221254-PUNCH-PL-JOK-ACP-LCCC-001

Re: Case Number: ABP-322242-25

Request for Further Information for Proposed Works at Bruree Bridge, Co. Limerick

TYPICAL PARAPET WALL SECTION SCALE 1:10

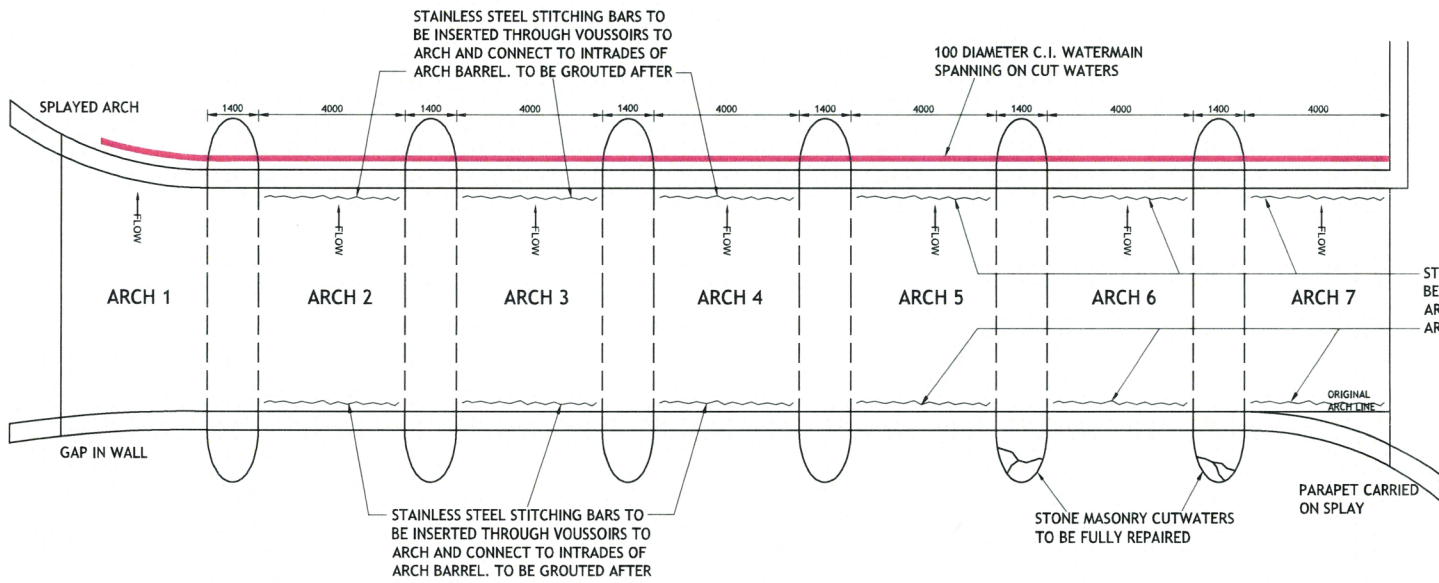
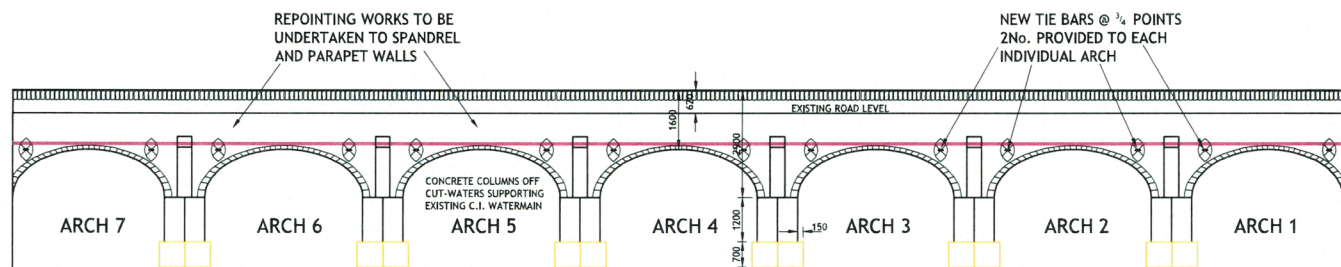
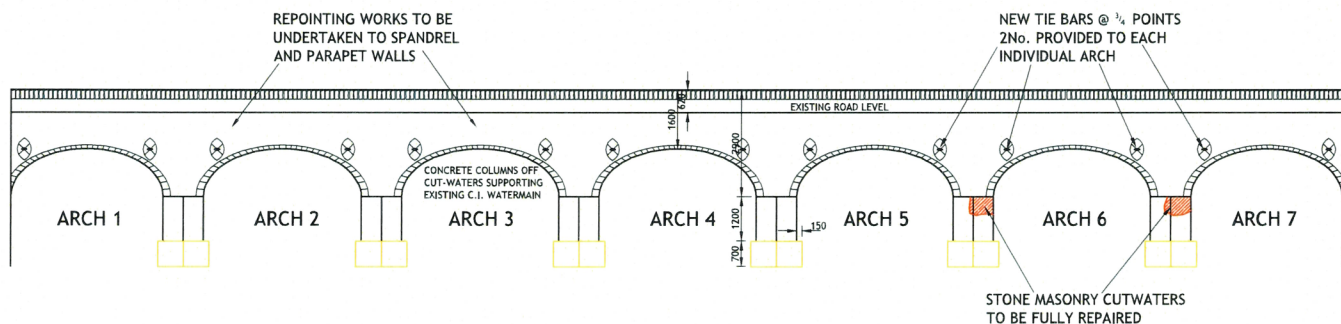
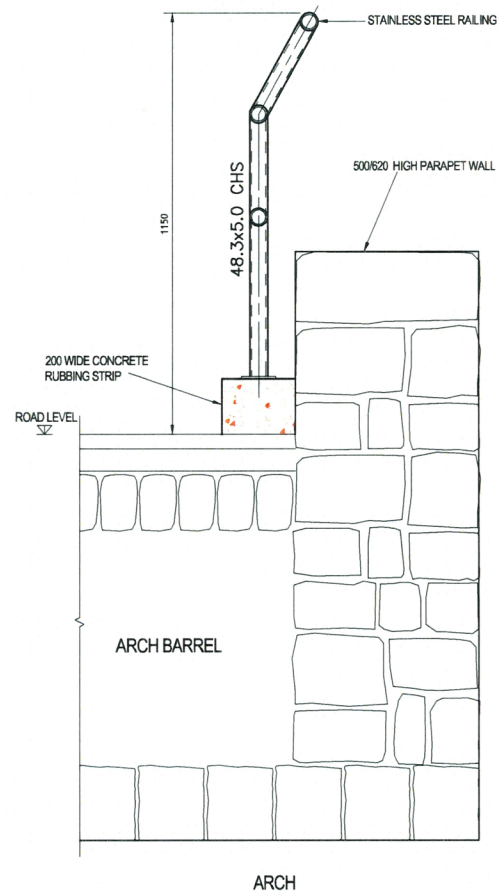
1. Detailed justification for the inclusion of the proposed railings, and their height and design, having regard to the visual and architectural impact on the protected structure and the provisions of the Architectural Heritage Protection Guidelines for Planning Authorities published by the Department of the Arts, Heritage and the Gaeltacht

The existing parapet walls are 500-620mm high and offer insufficient containment for pedestrians accessing the bridge and stainless-steel railings are proposed to address this concern. The railing containment shall be a minimum of 1100mm to Part K of the Building Regulations & BS 6180; with reference to 7.15 of the Architectural Heritage Protection Guidelines, there is a requirement to secure the health & safety of people as defined in the Building Regulations.

- Minimum effect on authenticity (fabric) - A contemporary stainless-steel barrier is proposed to make a clear distinction between the original bridge structure.
- Minimum Intervention - The railing will not impinge on the original structure as it will be readily defined by the difference between the original masonry and new steel material and not adversely interfere with the existing structure.
- Reversibility - The new stainless railing can be removed, allowing the bridge to return to its original state if required.
- Honesty of Intervention - The new railing is required as an additional safety measure to the bridge but does not try to imitate the original structure, keeping a clear distinction between old & new.
